**From:** Adrian Dowd  
**Sent:** 13 February 2019 12:39  
**To:** planning  
**Cc:** Adam Birkett  
**Subject:** RE: Consultation on planning application 3/2019/0049 and application for Listed Building Consent 32019/0050 Duke of York Inn, Grindleton Brow, Grindleton BB7 4QR

### **Application 3/2019/0049 and 3/2019/0050 Duke of York Inn, Grindleton Brow, Grindleton**

The application is for a change of use from a public house with living accommodation to one dwelling with business use. Demolition of existing single-storey extensions and construction of new single-storey extension. Construction of new, two-storey, three-car garage with business storage above. Construction of three new two-storey holiday lets.

Drawing Title
 PROPOSED HOLIDAY LETS:
 ELEVATIONS

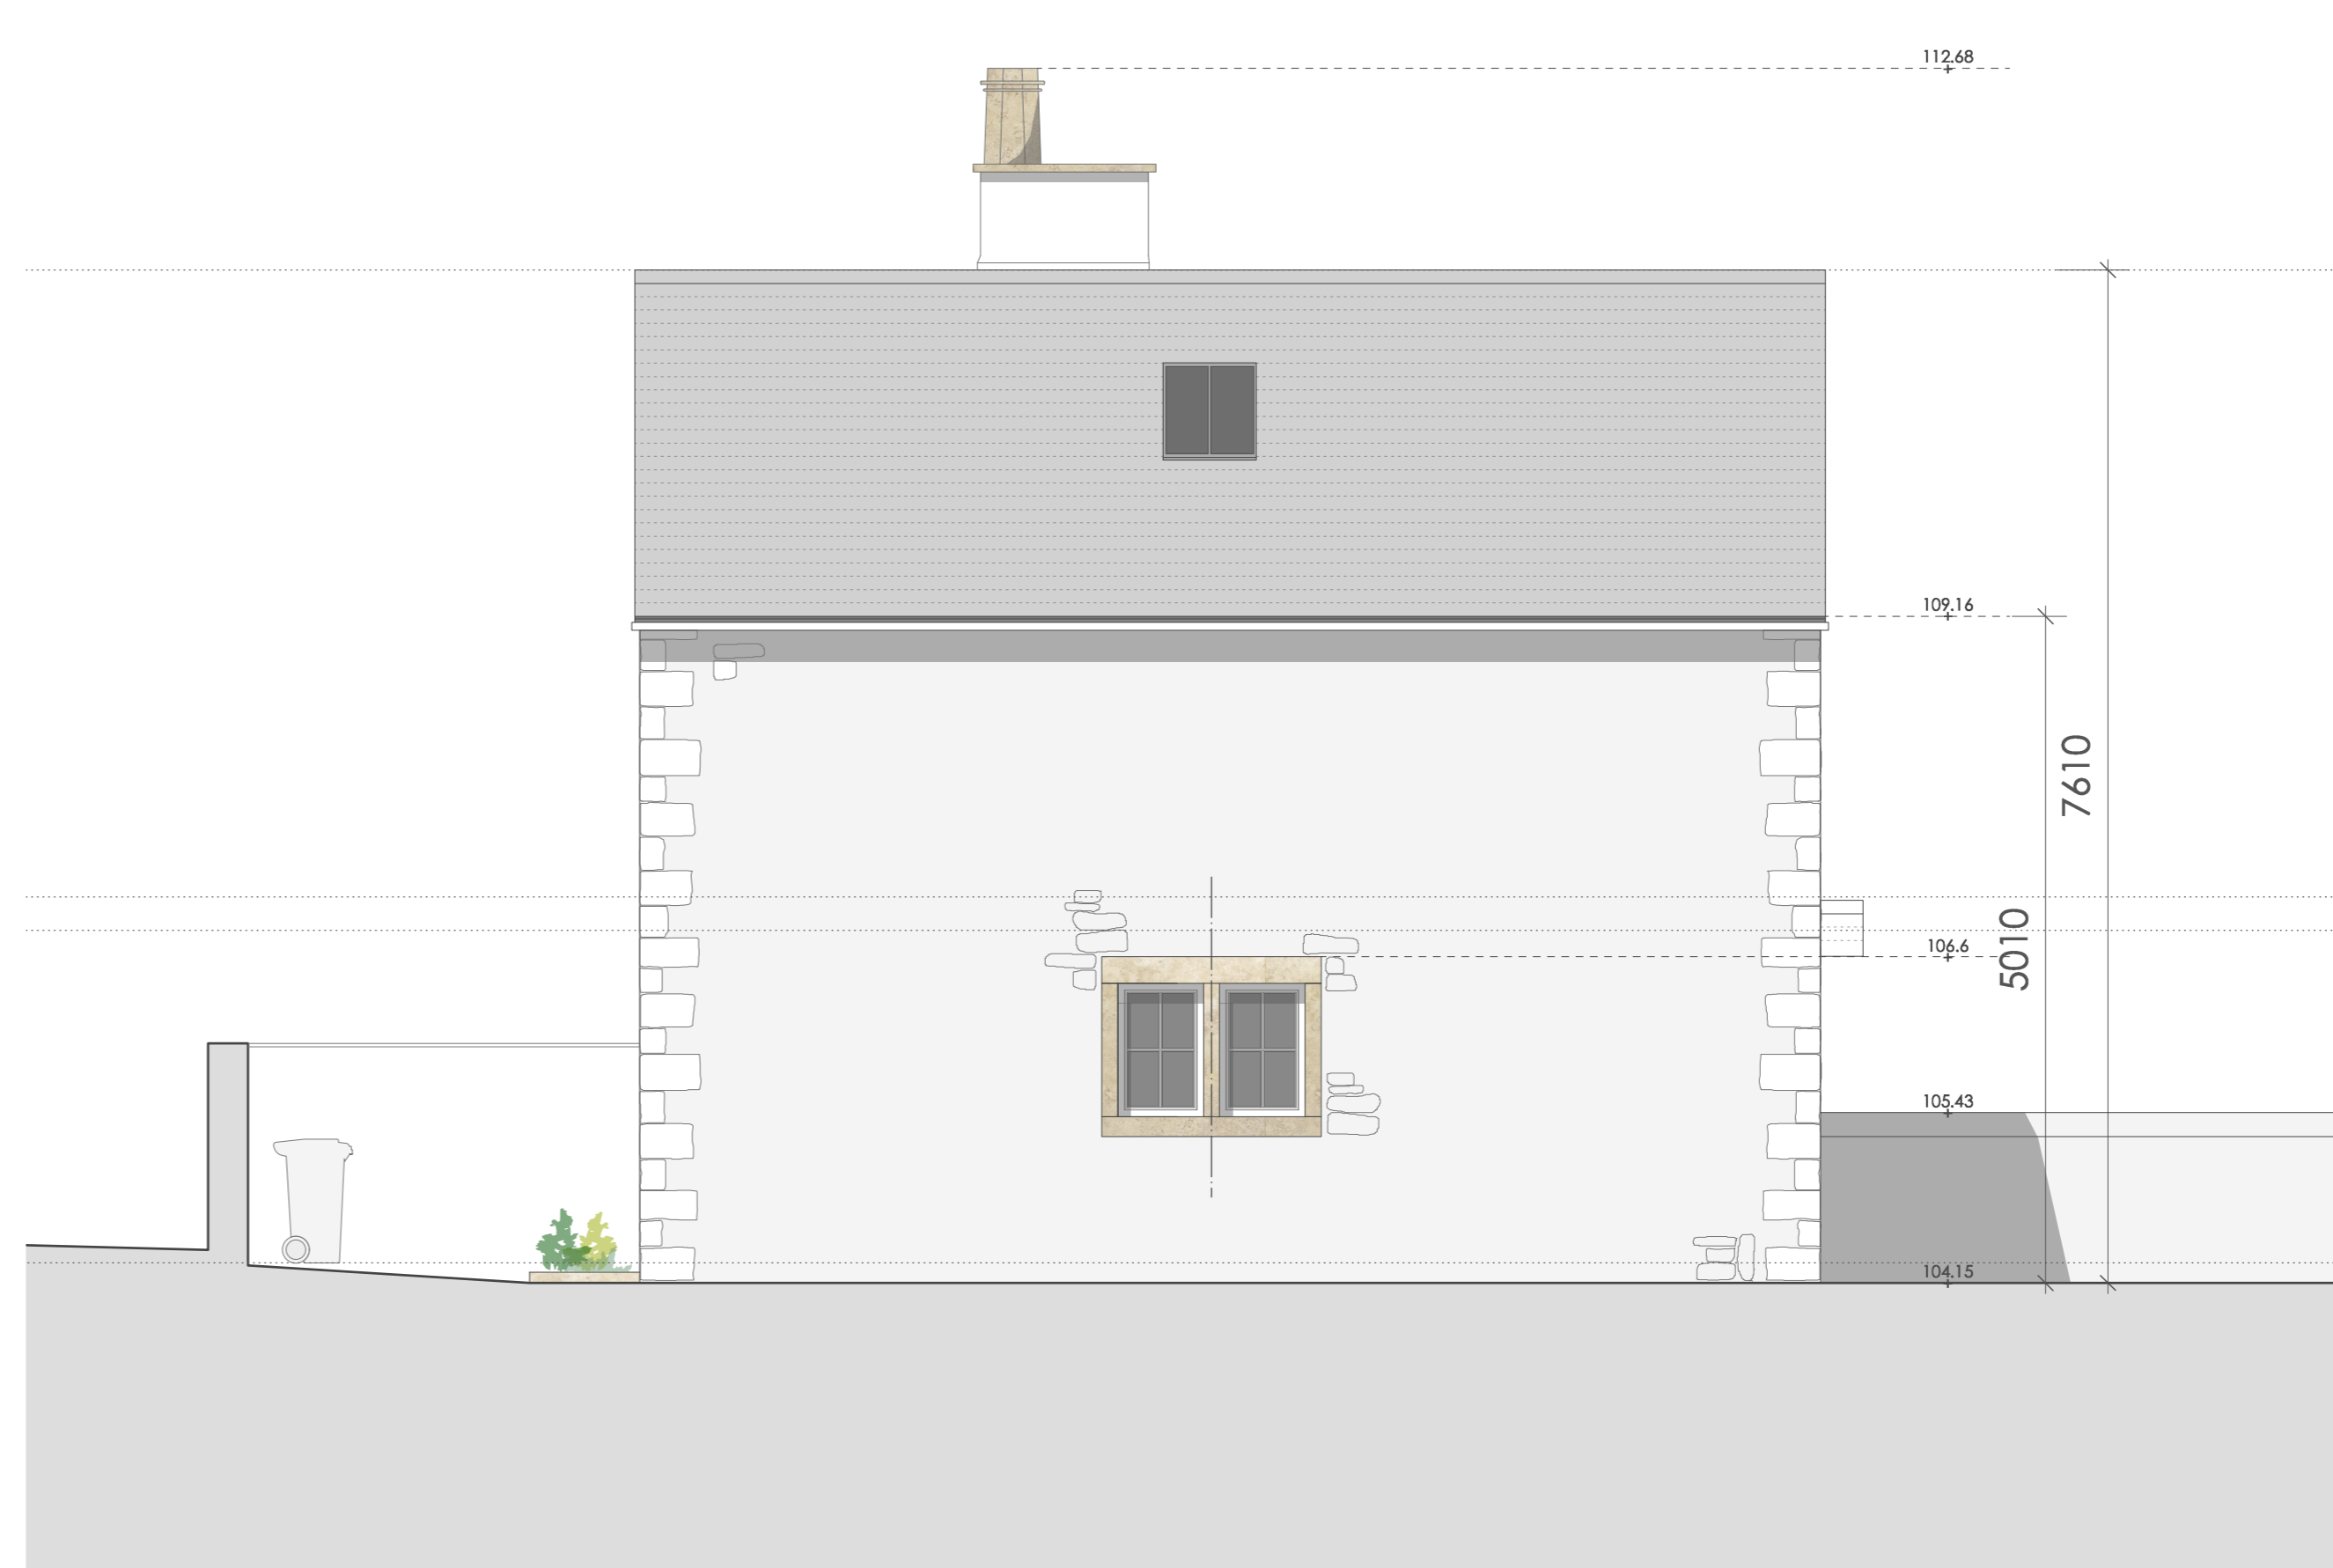
*“It would not normally be good practice for new work to dominate the original asset or its setting in either scale, material or as a result of its siting”* (‘Making Changes to Heritage Assets’, Historic England, 2016, paragraph 41). The holiday let block (projecting forward of the listed building’s façade) and garage/store block are prominent, incongruous and intrusive. There is an intrinsic and historic relationship between the Duke of York and the land immediately to the building’s west and north. Furthermore, this open area is a fitting apron to one of a small number of architecturally ‘polite’ buildings in Grindleton and ensures that the listed building rightfully retains its intentionally imposing (to capture passing trade) place in the streetscene and at the entrance to the village from the west (‘Focal Building’).
